## **SUBMISSION AS THE LOCAL PLANNING AUTHORITY**

1.1. This submission is made in response to the action points and additional information as requested by the ExA during the examination period for ISH1 – ISH5 which took place between the dates of 3<sup>rd</sup> December 2024 and 5<sup>th</sup> December 2024 (inclusive). This list should be read in conjunction with the action point documents published by the ExA referenced as EV7-001 (ISH1), EV8-001 (ISH2), EV9-001 (ISH3) and EV10-001 (ISH4). It should be noted that no formal action points were recorded for ISH5. Action point raised as part of the CAH2 is within the Land Owners section of the Council's examination summary submission.

DRAWING NUMBER HE551478	ORIGINATOR SKAG	VOLUME EAQ	PROJECT REF NO. HE551478
LOCATION CONWI_CONW	TYPE DR	ROLE LA	REVISION C01
NUMBER 00032

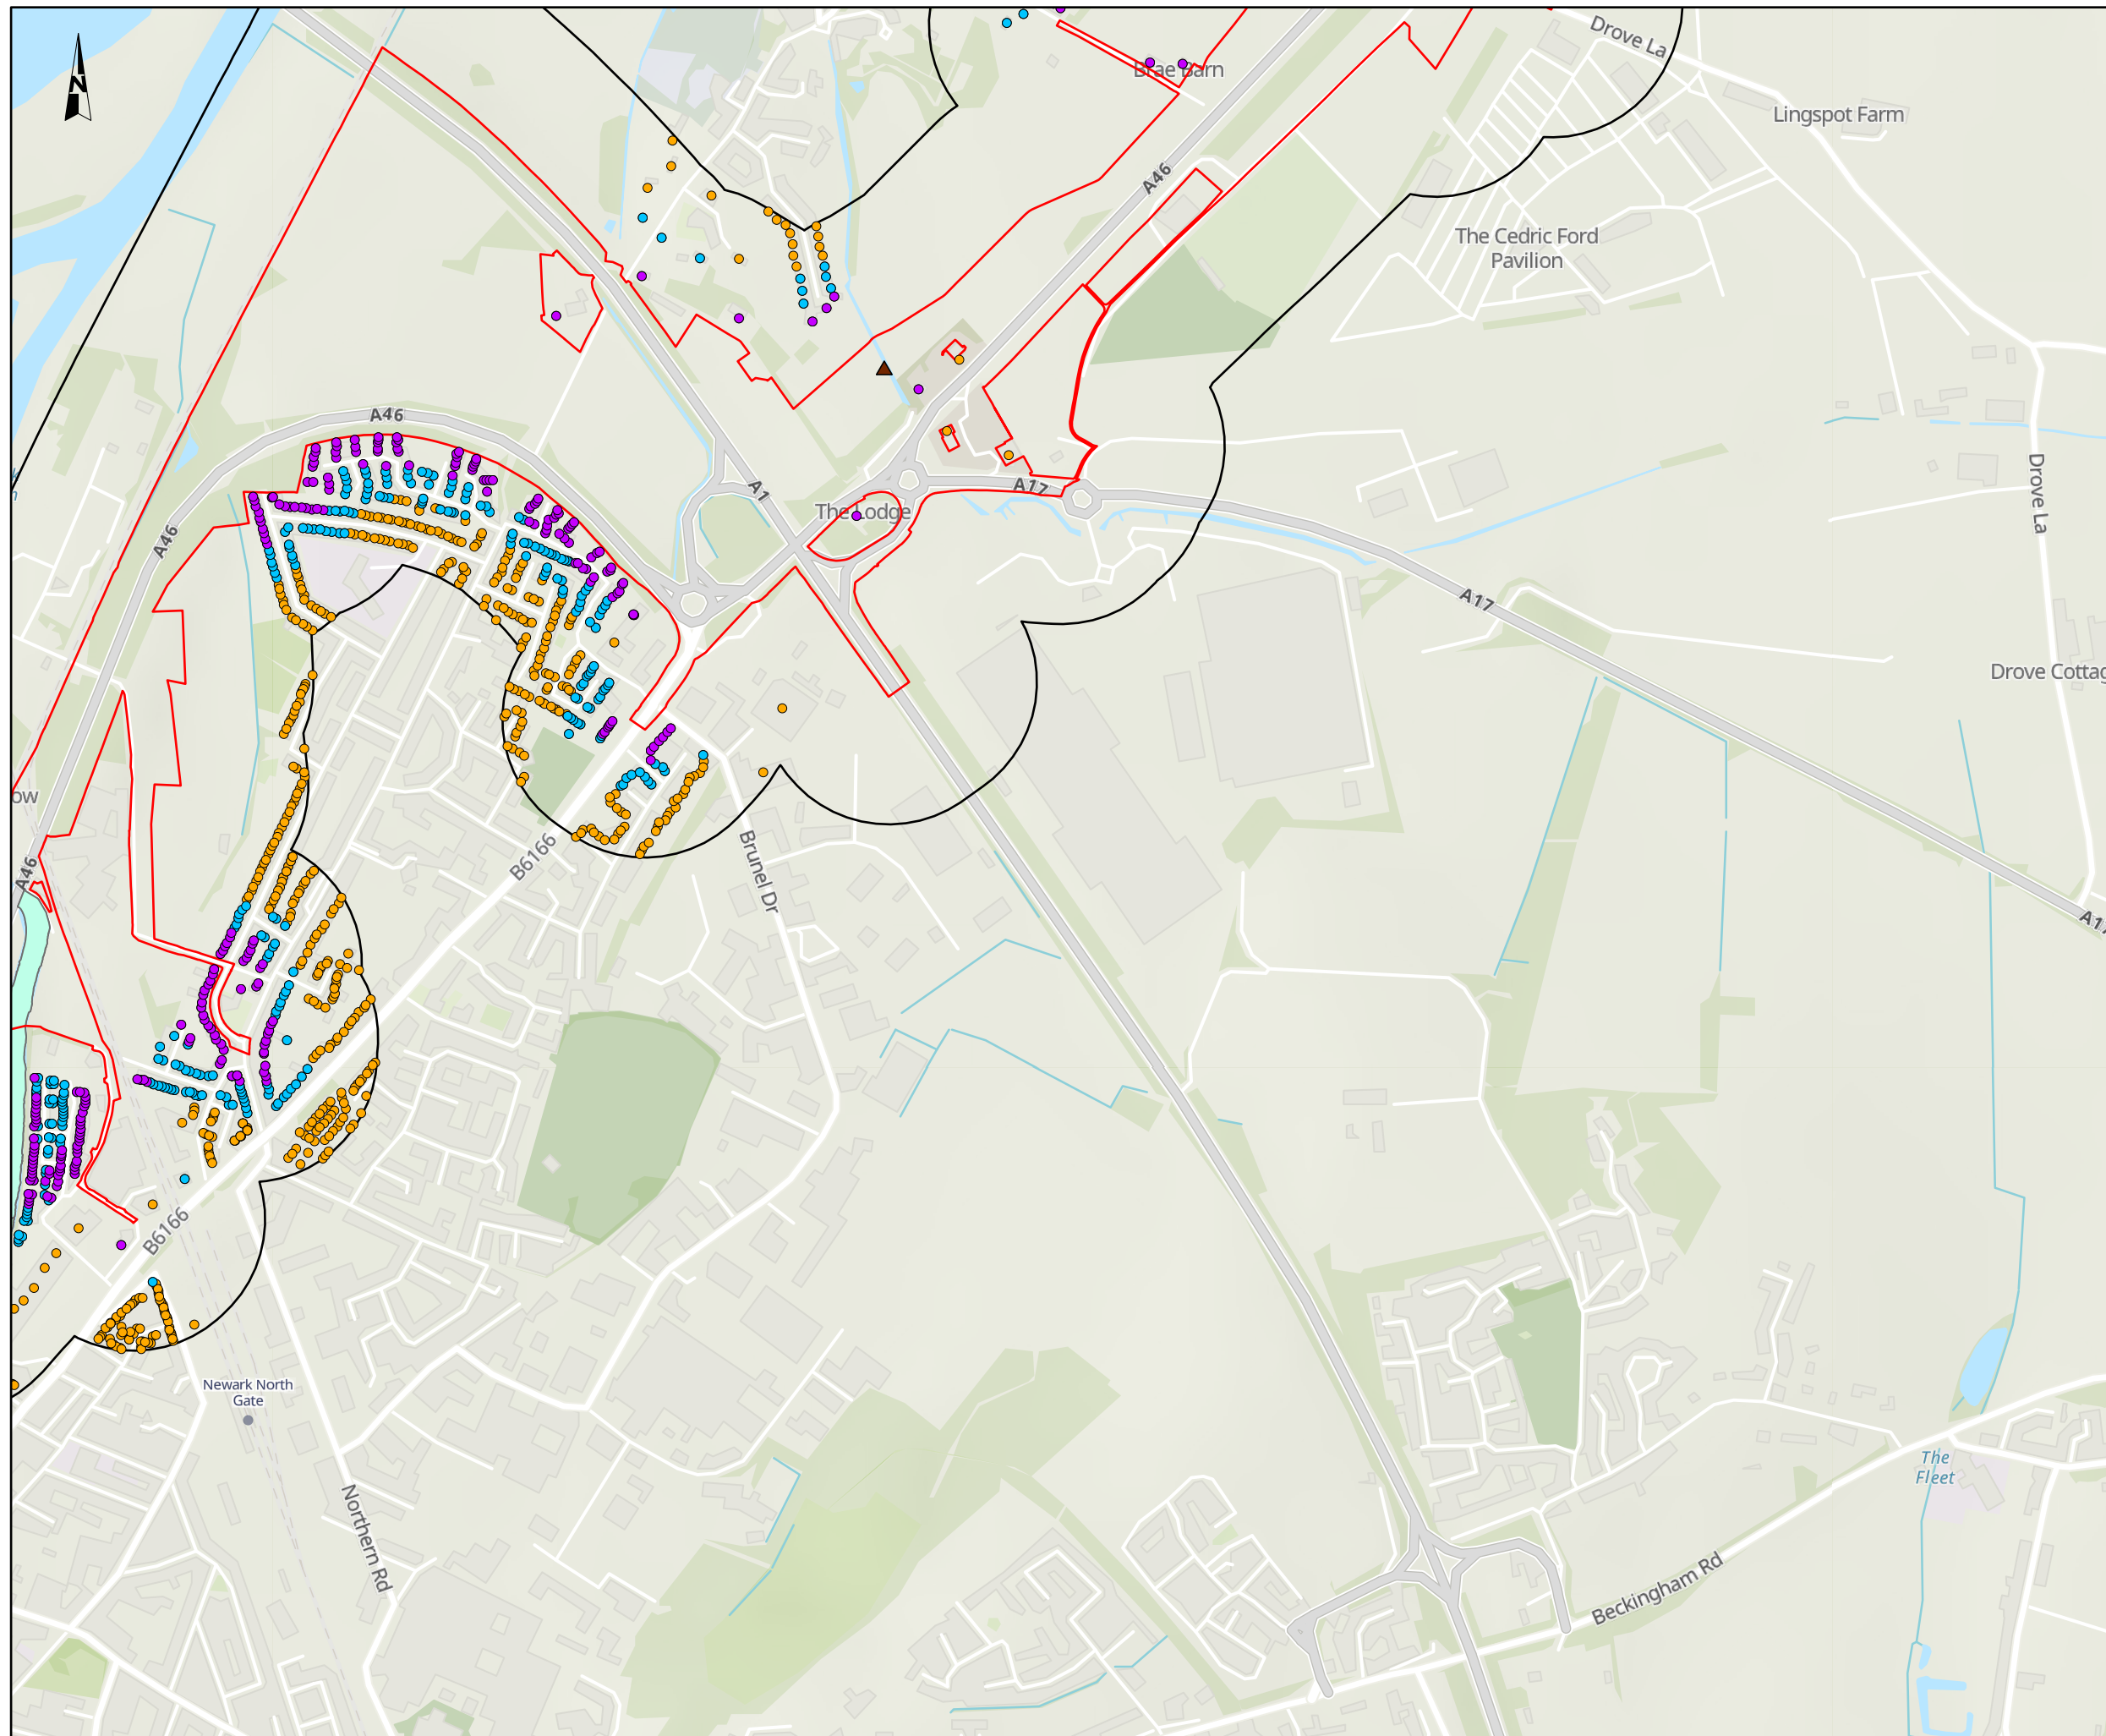
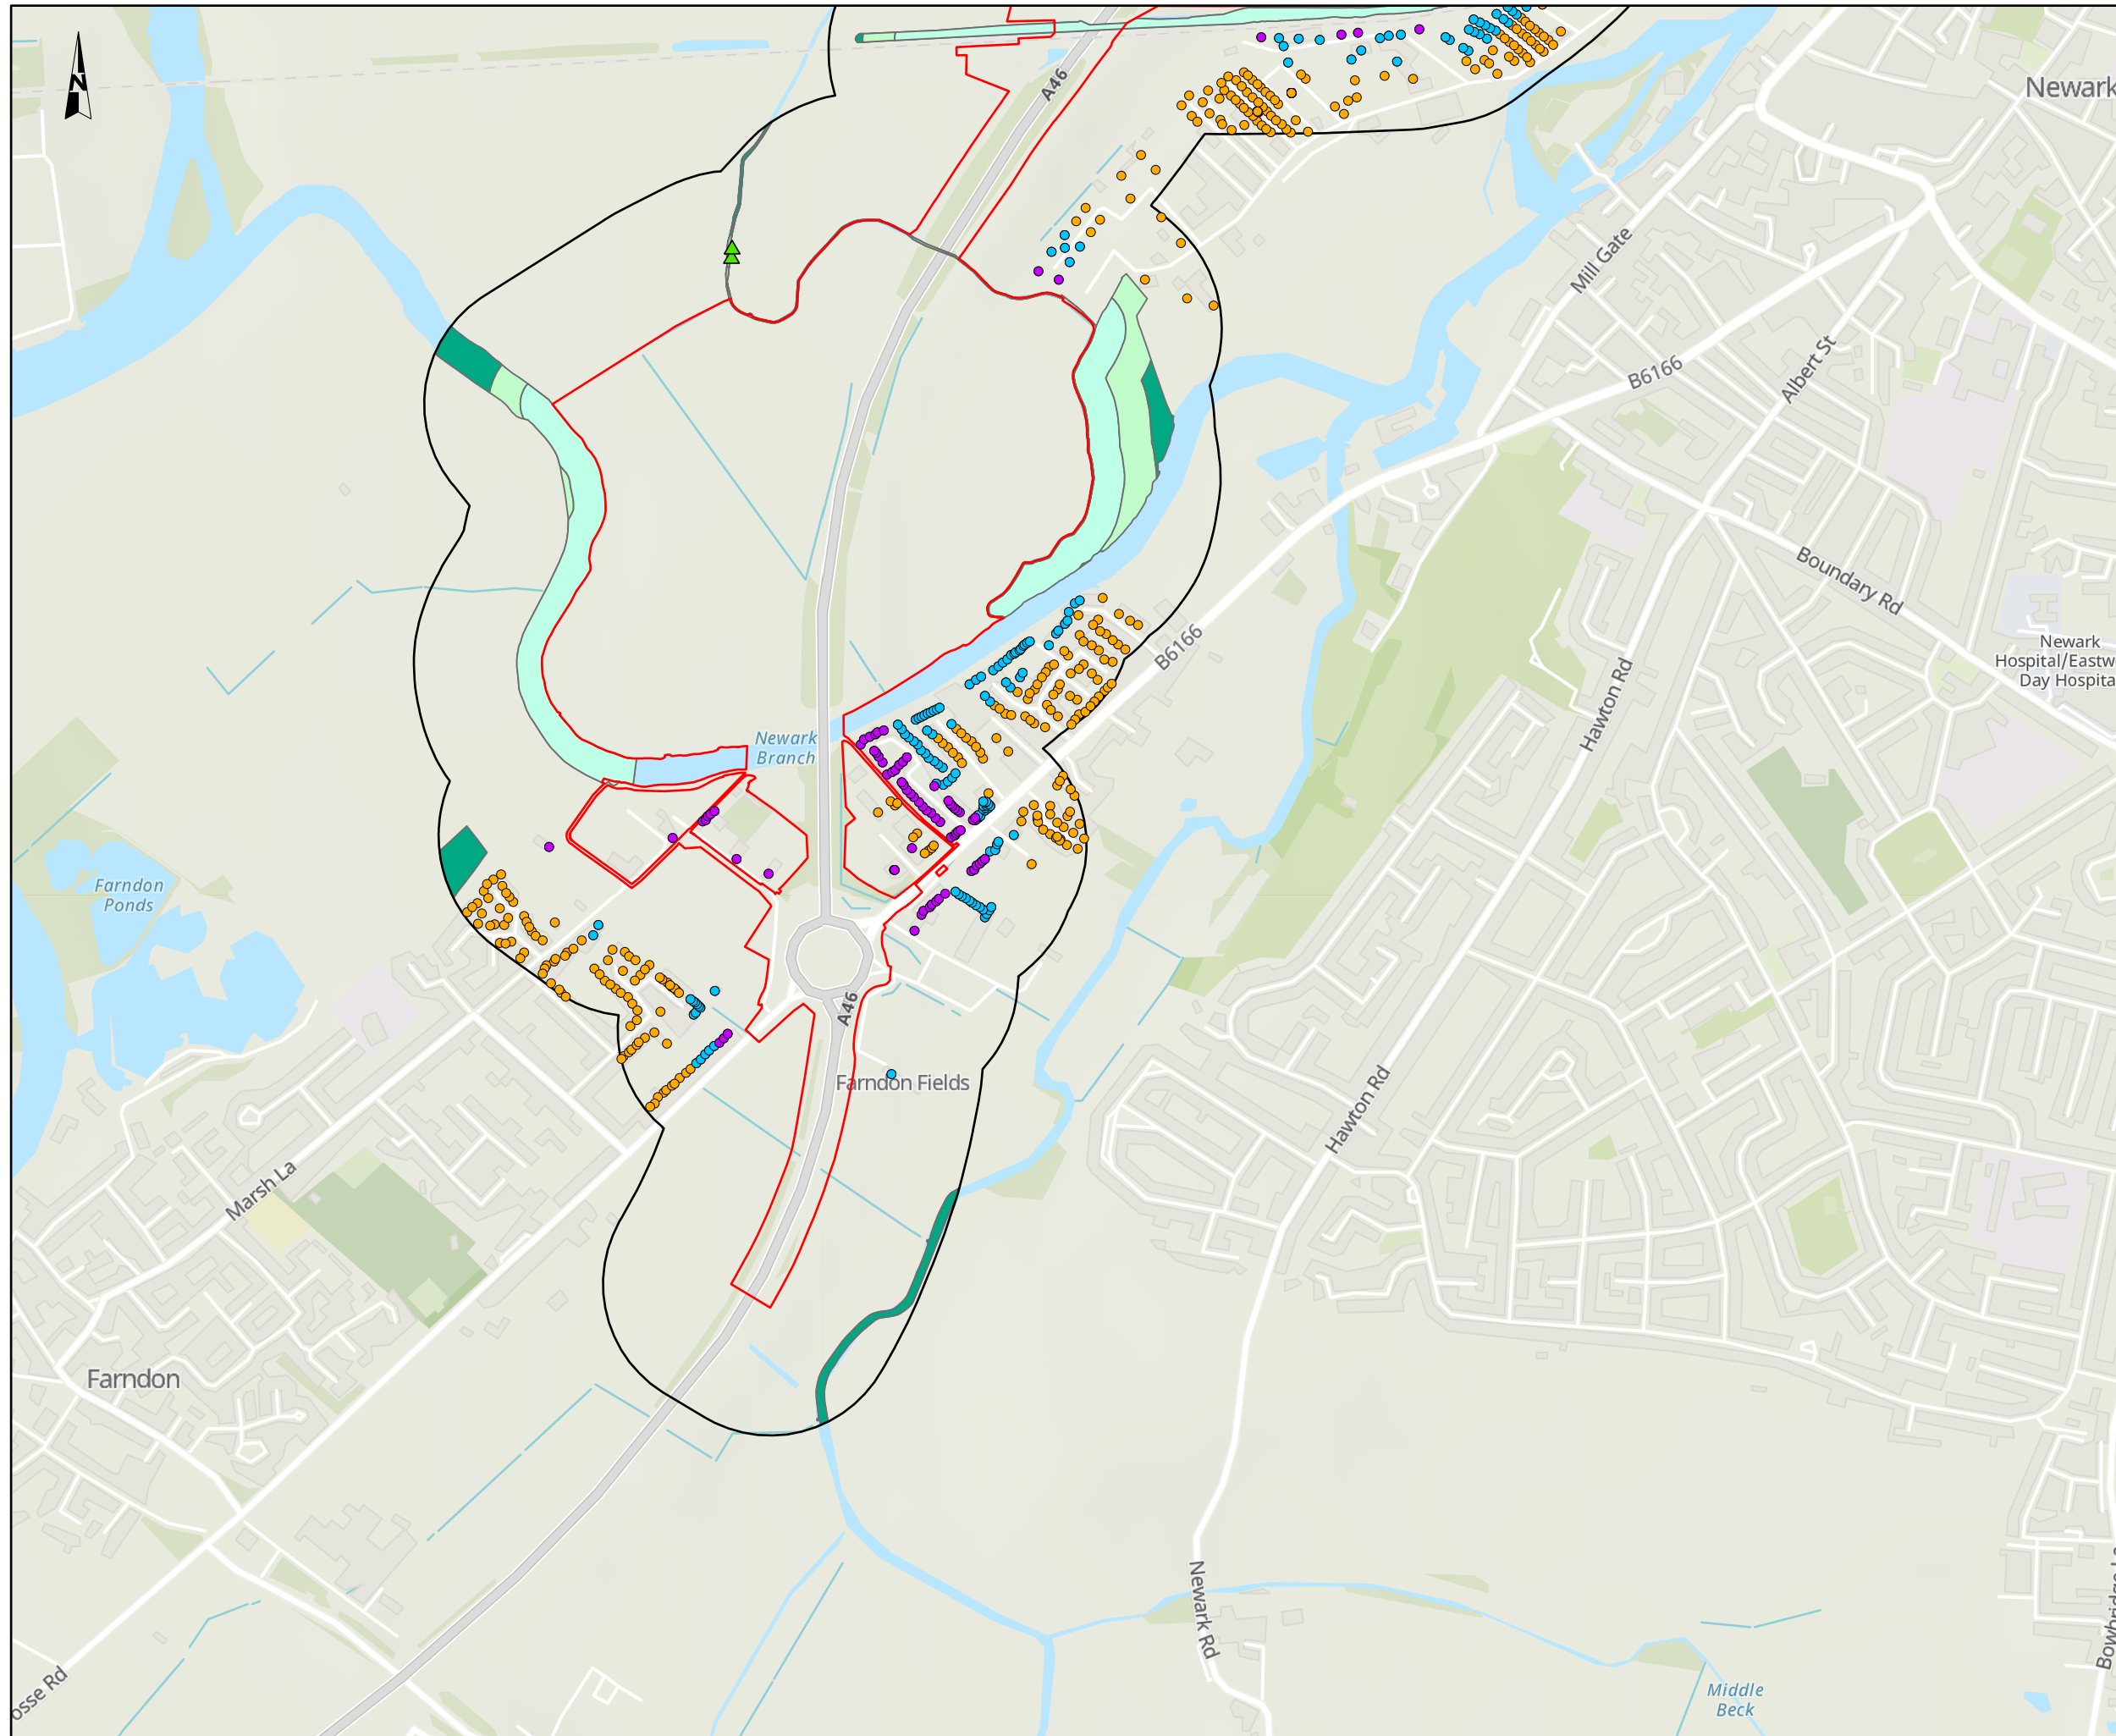
- Table 1-3 the mitigation measures concerning 'preparation and maintaining the site' are repeated.
- A figure would be useful to illustrate the locations of the higher risk areas as detailed in Table 1-2. It is acknowledged that in Environmental Statement, Figures 5.3 [TR010065/APP/6.2], receptors are identified which are located within 100 m of the site boundary; however, it appears more information is now available to identify receptors within 100 m of specific works. Therefore, an updated figure would be helpful to understand where additional specific control measures will be implemented.
